Comhairle Contae Chill Mhantáin Wicklow County Council

22nd August 2022

**RE: PROPOSED APPLICATION FOR DEVELOPMENT OF 586 UNITS (312 IN WICKLOW) AT
FORMER BRAY GOLF CLUB LANDS, BRAY, CO. WICKLOW**

Drawing Title: WCC - Part V

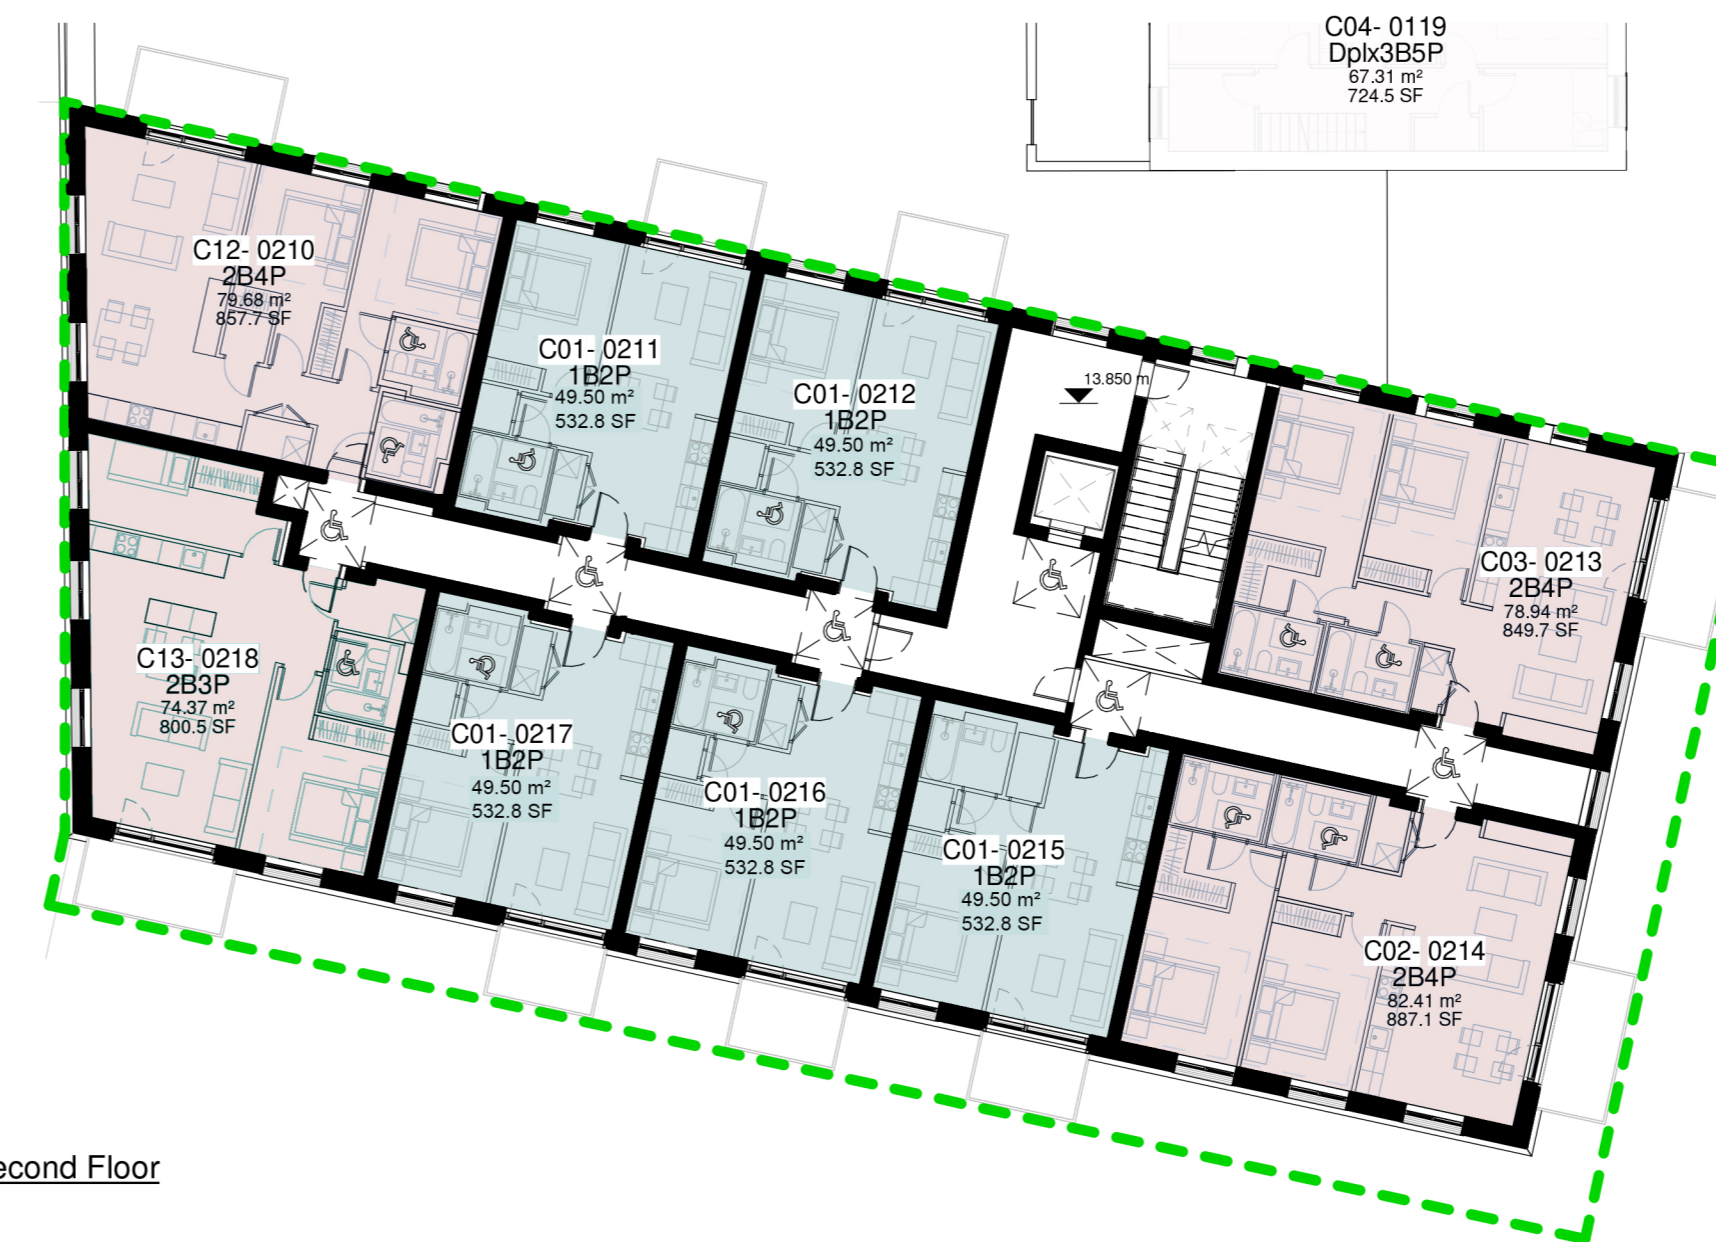
Subject to Contract and to further detailed agreement upon the grant of a Planning Permission for the above development, I can confirm that Wicklow County Council is agreeable in principle only that if your Company qualifies for the transition arrangements in respect of Part V that your clients Part V obligations may be satisfied by the provision of 34 units as follows:

20 x 1 bed 2 person apartments
11 x 2 bed 4 person apartments
3 x 2 bed 3 person apartments

As included in your submission received 9th August 2022 and outlined in Drawing WCC-Part V No. BRA-GHA-Z1-XX-DR-A-04002 dated 2nd August 2022.

Please ensure that all of the Part V units offered are in accordance with the target areas as set out in the Quality Housing for Sustainable Communities (allowing up to 10%). Please note that en-suites are not required.

While the Council's preference is for houses these units do meet a significant need in the area and may be acceptable.
